REFUSAL OF PLANNING PERMISSION

APPLICATION NO. 2016/0102

Proposal Erection of two storey side extension to dwelling.

At 19 Strafford Avenue, Ward Green, Barnsley, S70 6SU

FRONT ELEVATION A - A
SCALE 1:100

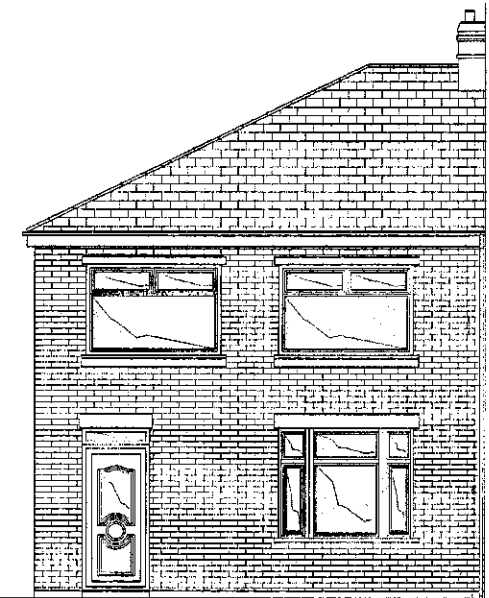
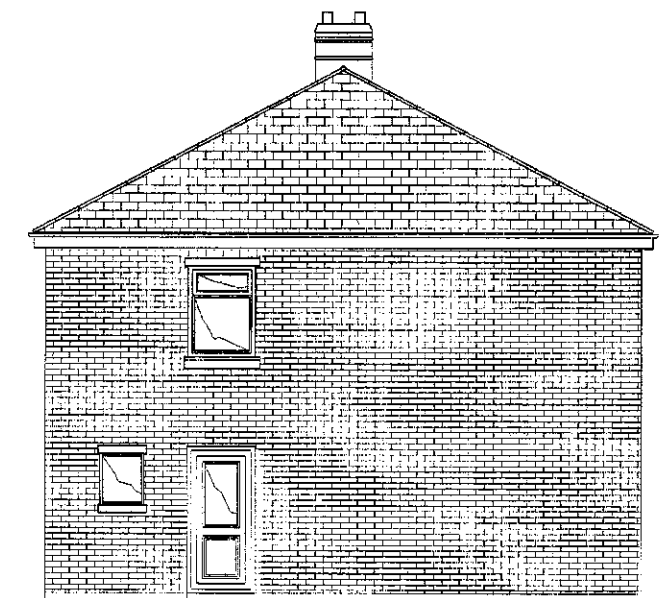
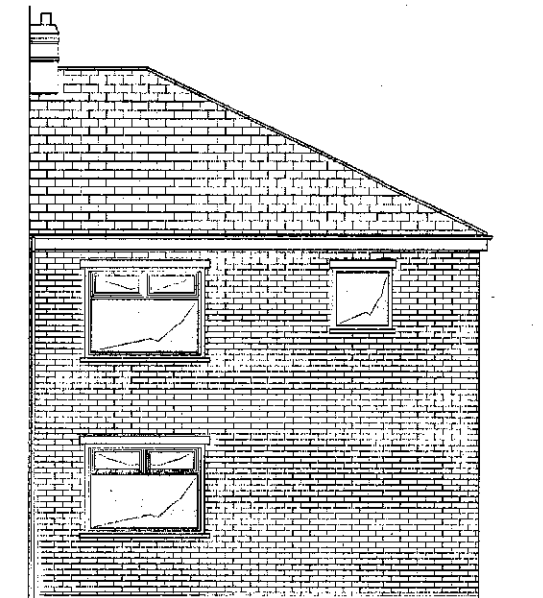
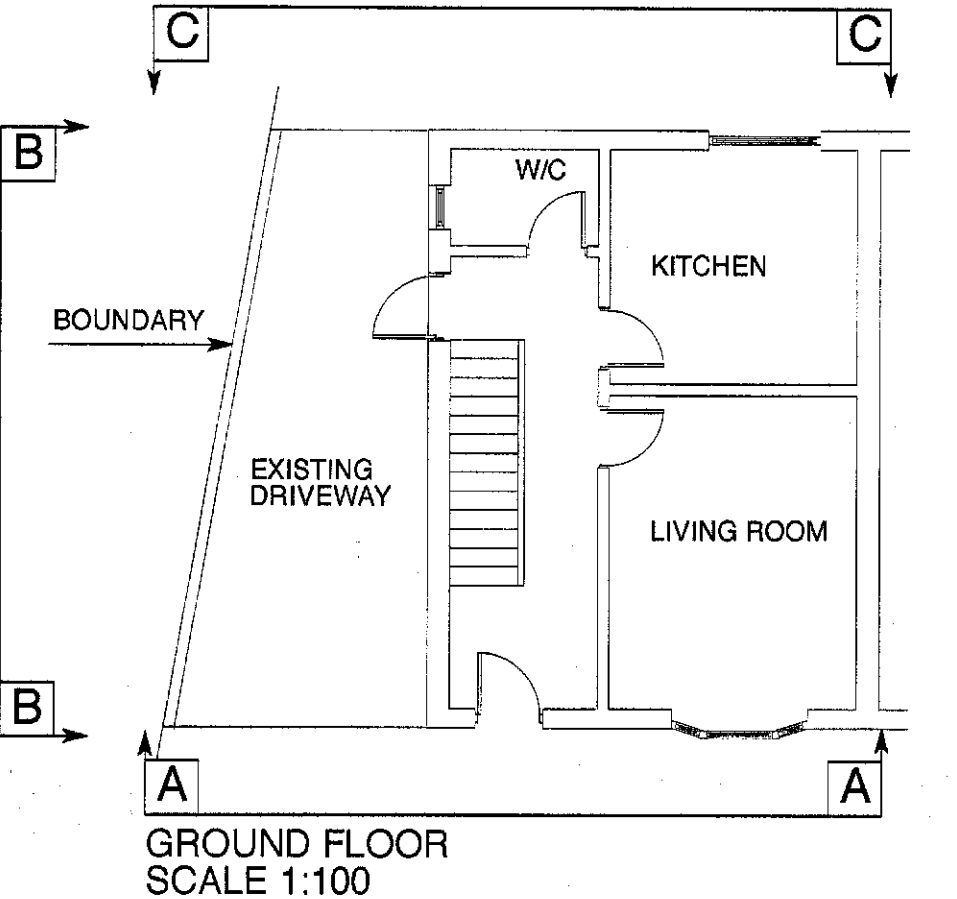
- 1 The proposed two storey side extension would have no setback from the principal elevation of the property. The Council's adopted Supplementary Planning Document - House Extensions (SPD) states that 'an extension should appear as an extension and particularly in the case of two storey side extensions a small setback of the extension from the main wall will be required. This will ensure that the extension appears subordinate and will help in reducing the terracing effect that may arise where several dwellings have been extended'. More specifically in respect of two storey side extensions, the SPD states that 'linking or closing the gap between semi detached properties to give the effect of a terrace, is a detrimental change to the character of the street scene and must be avoided. To prevent a terracing effect and to avoid detrimental changes to the character of the street scene, it will be desirable to provide a setback of at least 500mm from the main front wall of the dwelling. A setback from the front elevation allows for a vertical break in the roof plane and a lowering of the ridge line'.

The proposed extension therefore is contrary to the SPD and as a result would have a terracing effect detrimental to the character of the street scene. The proposal is also considered to be contrary to CS policy CSP29 and the relevant planning policy statements in the NPPF relating to requiring good design in that the proposed development would not be appropriate to its context, would not respond to local character and would be detrimental to the overall quality of the area.
